Martin Nugent  
01254 828060  
D3/12/0198

Drafted 10 July 2012

**Planning Application, Ribble Valley District  
D3-12-0198 Backridge House, Twitter Lane, Waddington**

Site plan & elevations of dry stone walls as proposed

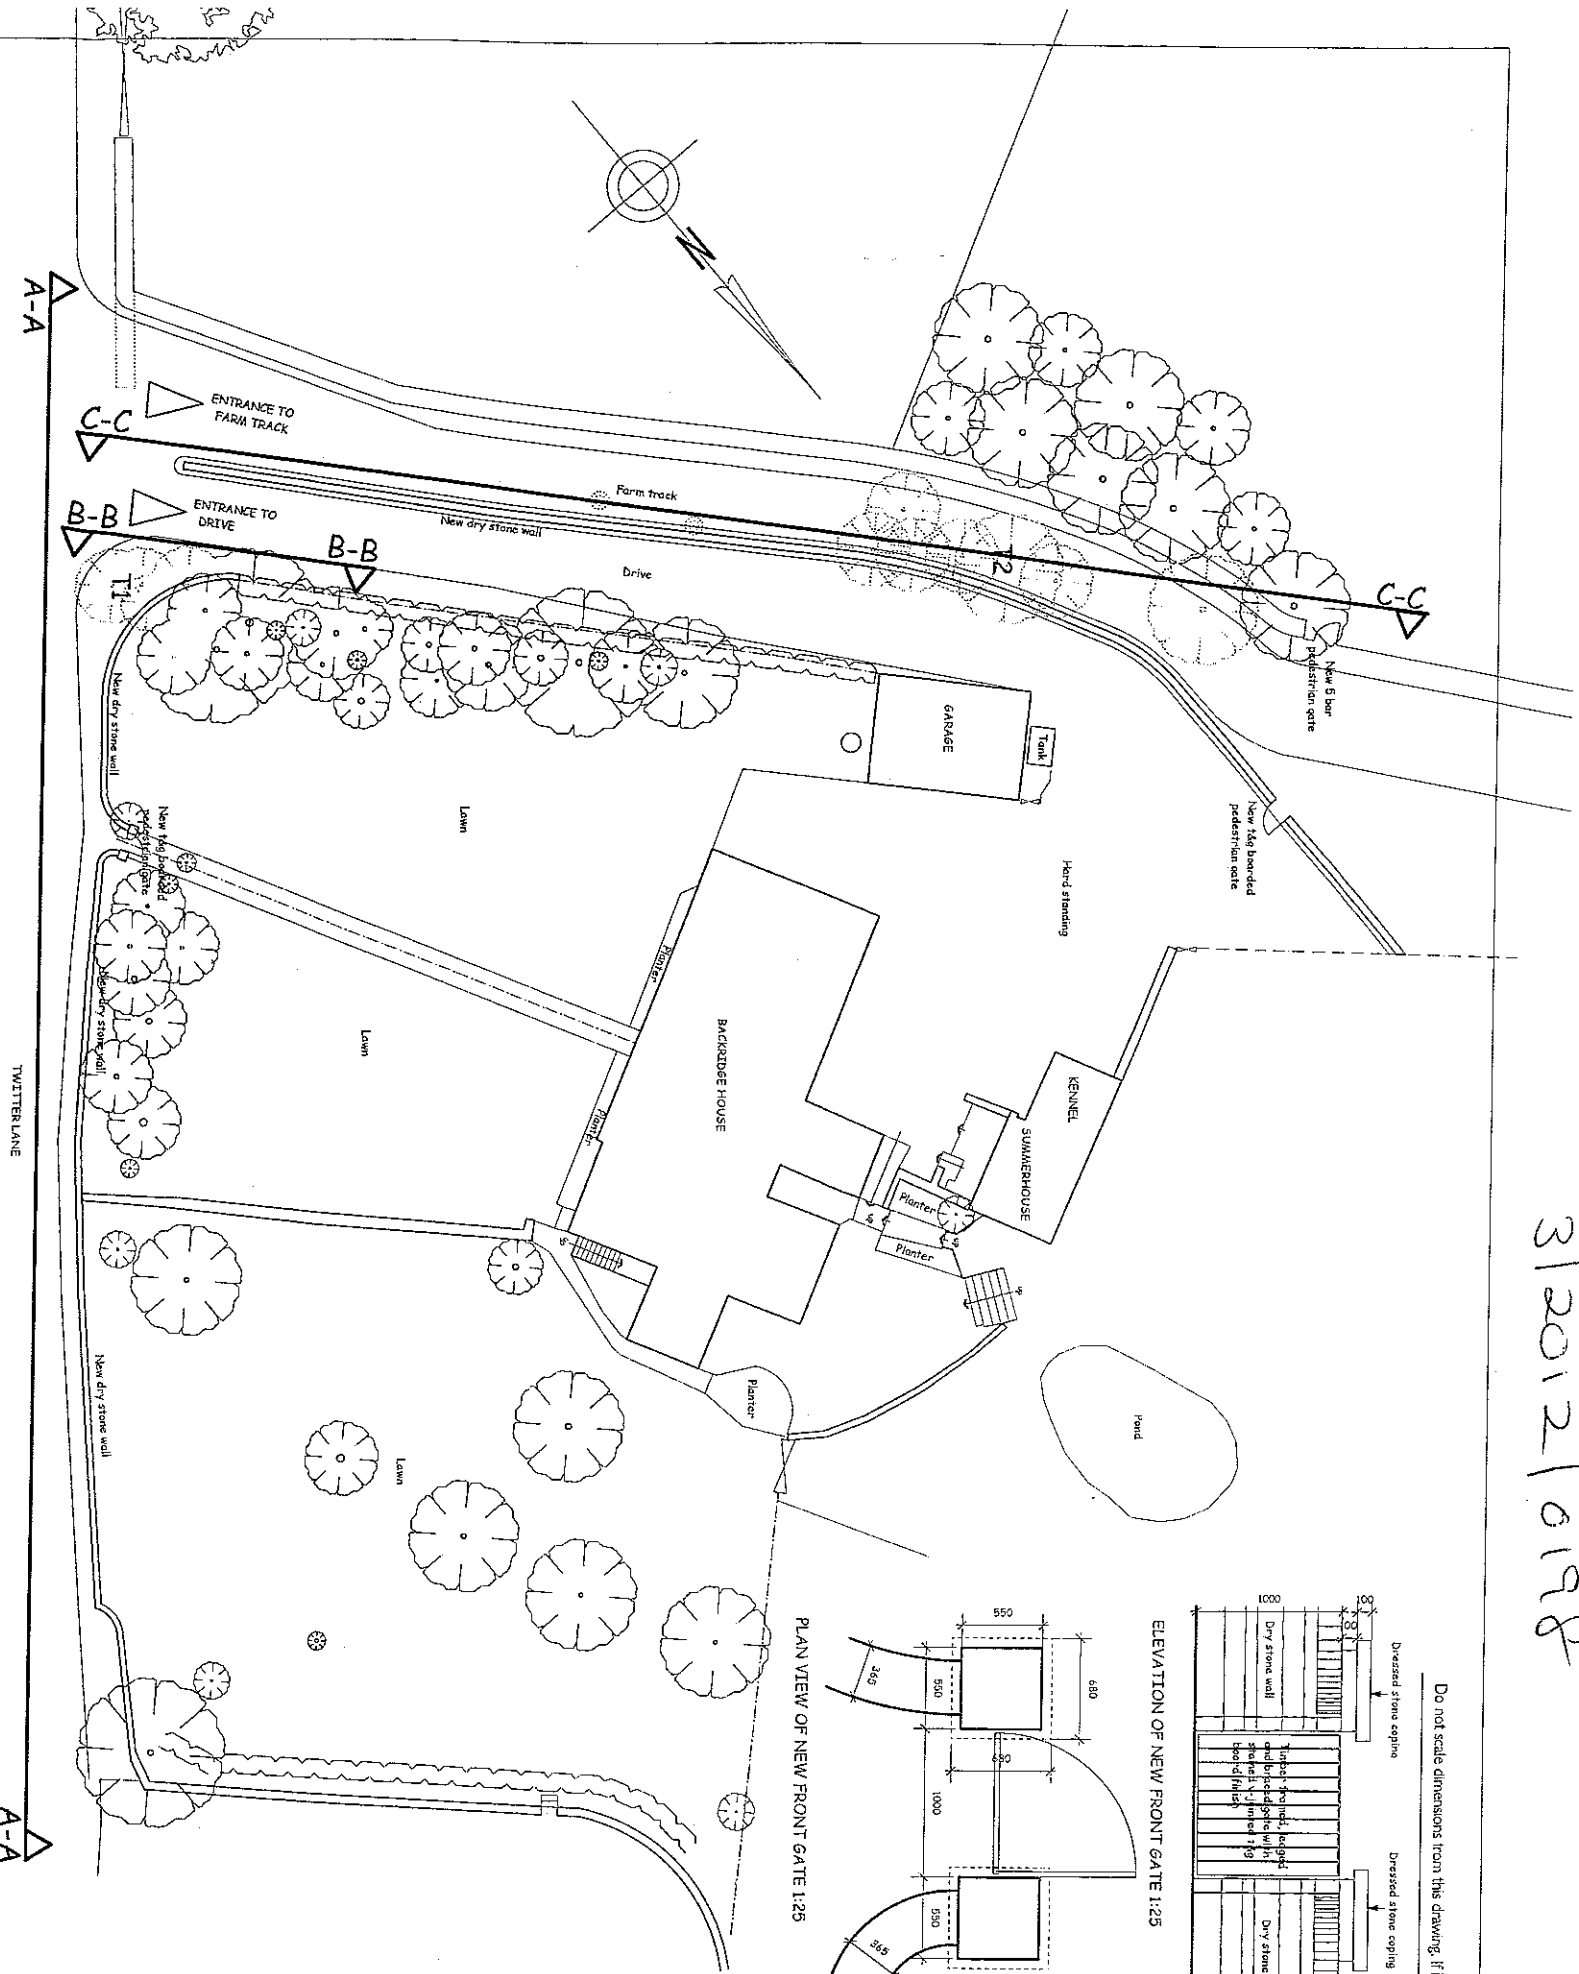
However, I would welcome a more detailed drawing for the proposed dry stone wall separating the farm and domestic accesses. This should include a suitable service strip, 1.0m minimum width to either side of the wall to allow any future maintenance to be carried out without having a detrimental impact on their ability to function safely and efficiently.

Drawing Title: EXISTING & PROPOSED ACCESS ARRANGEMENTS

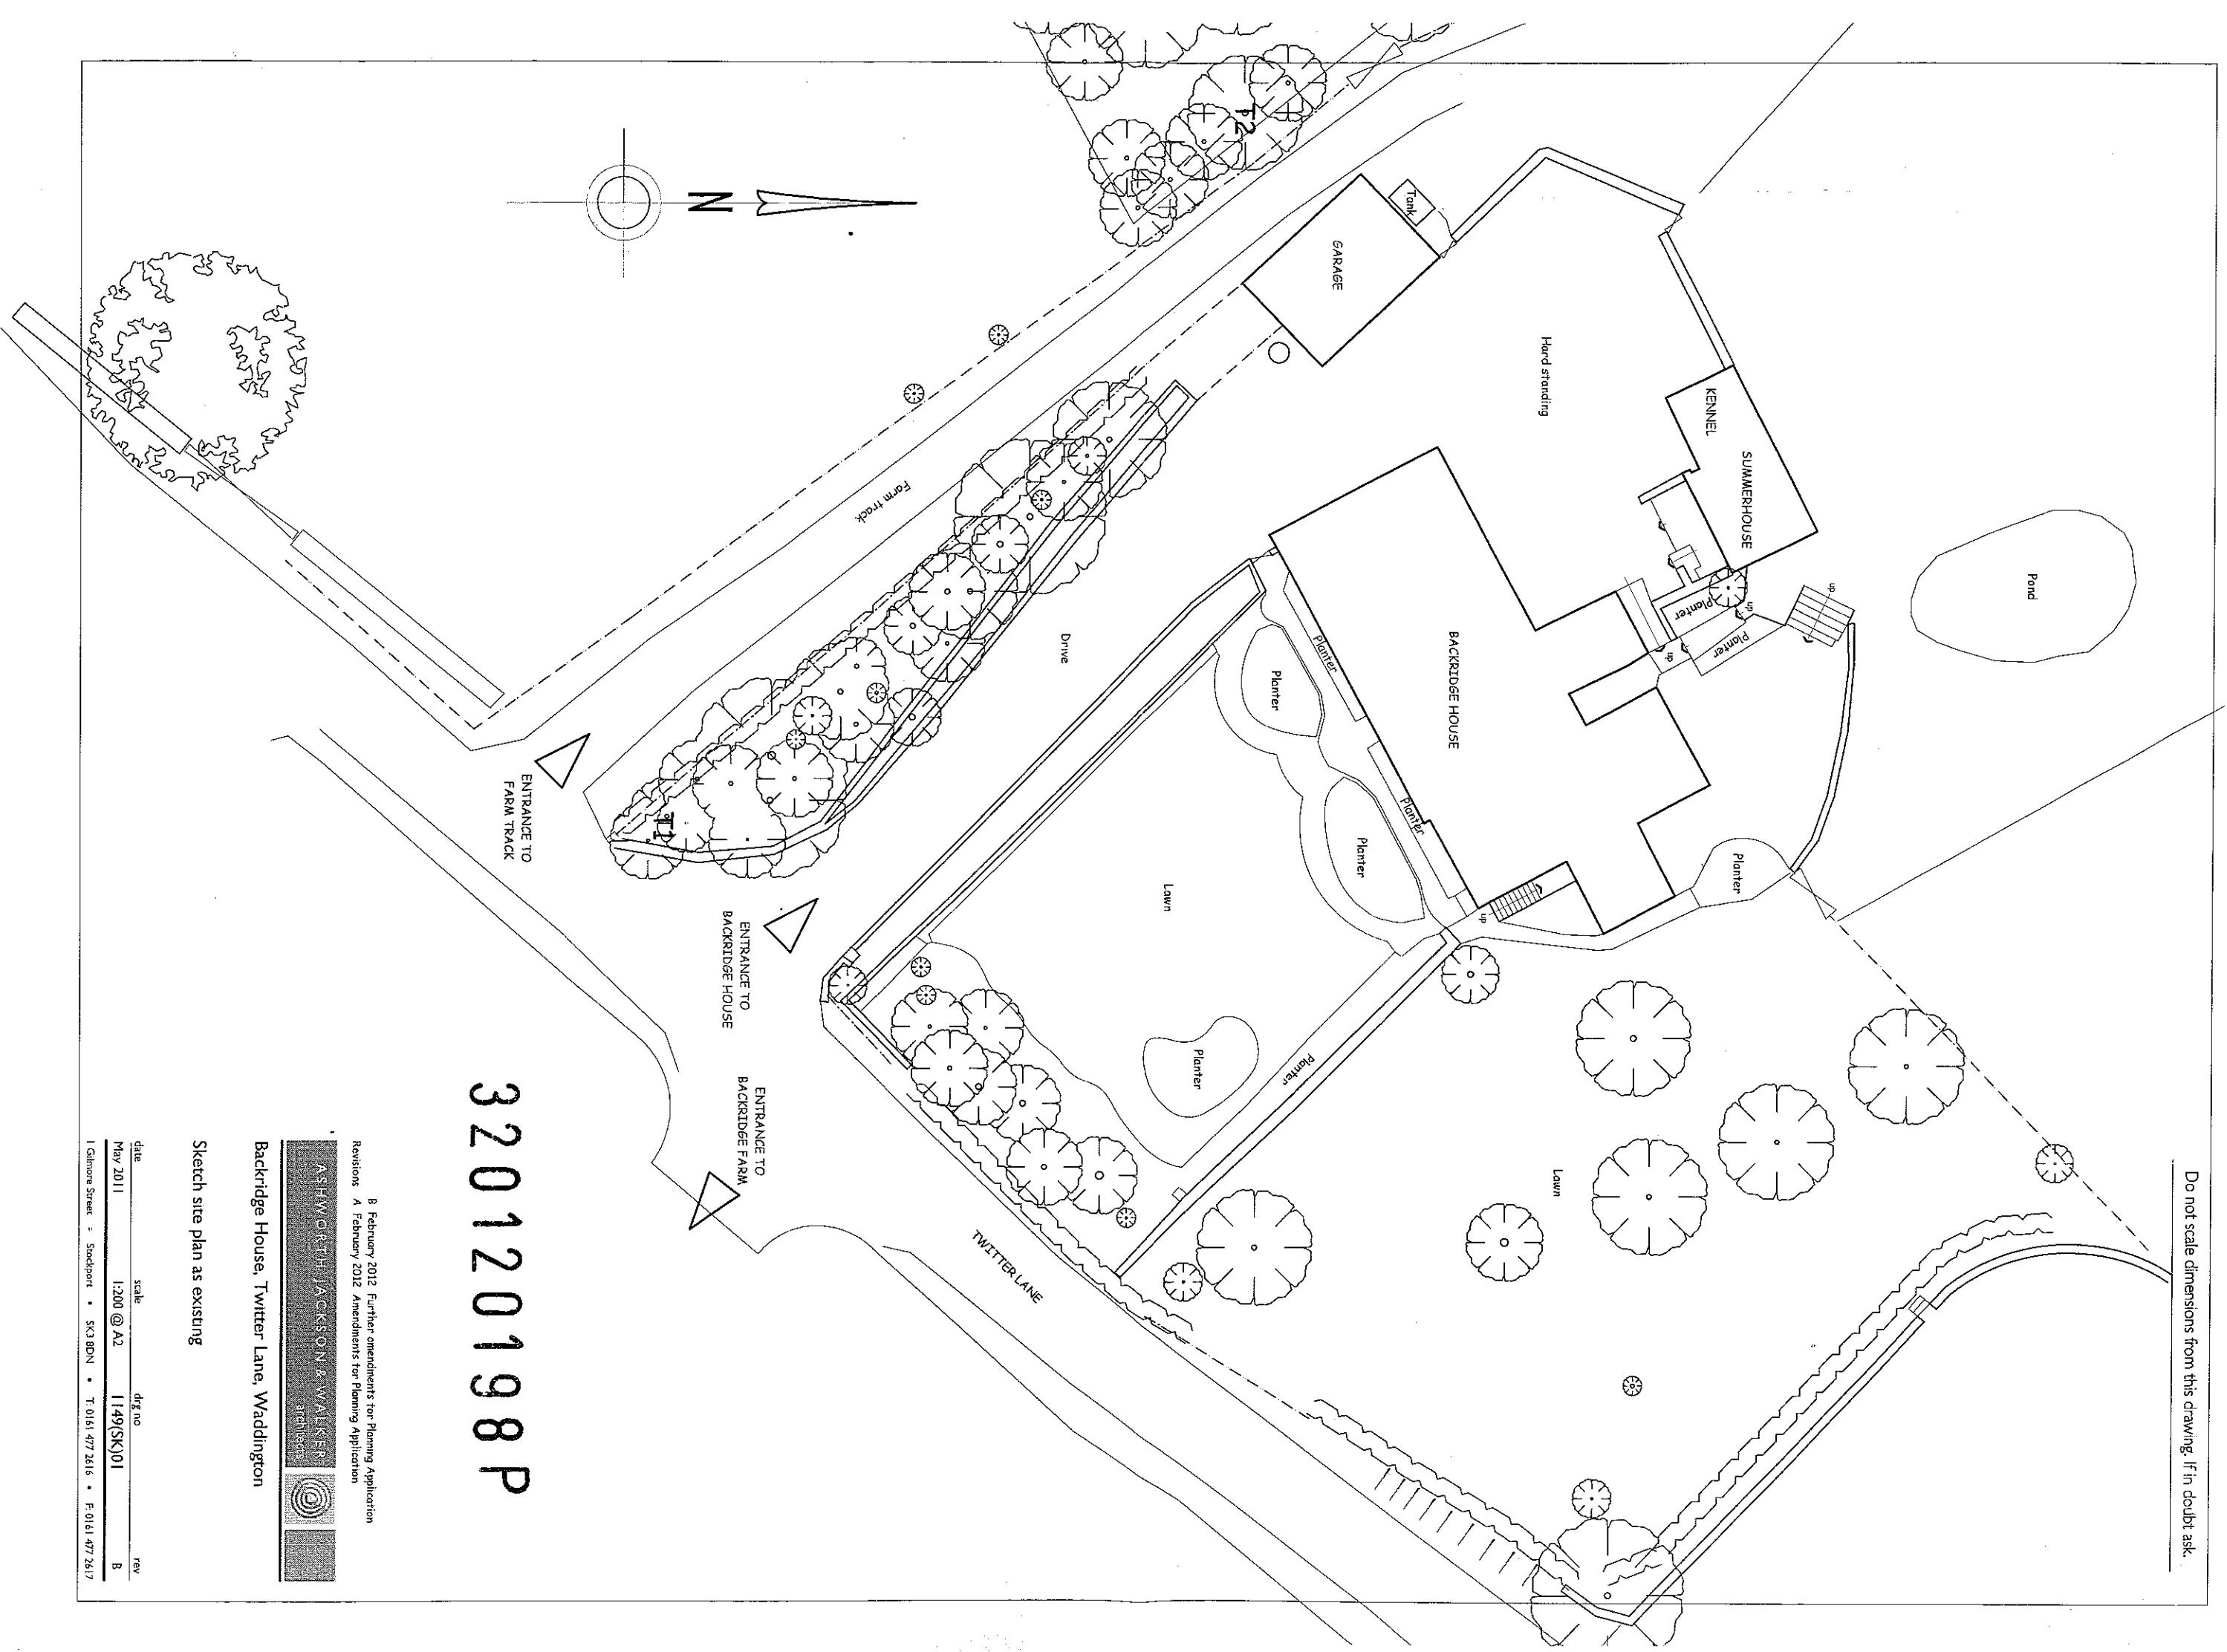
The visibility splays that can be achieved from the proposed layout, as measured from the site plans provided and verified on site, are an improvement on the existing.
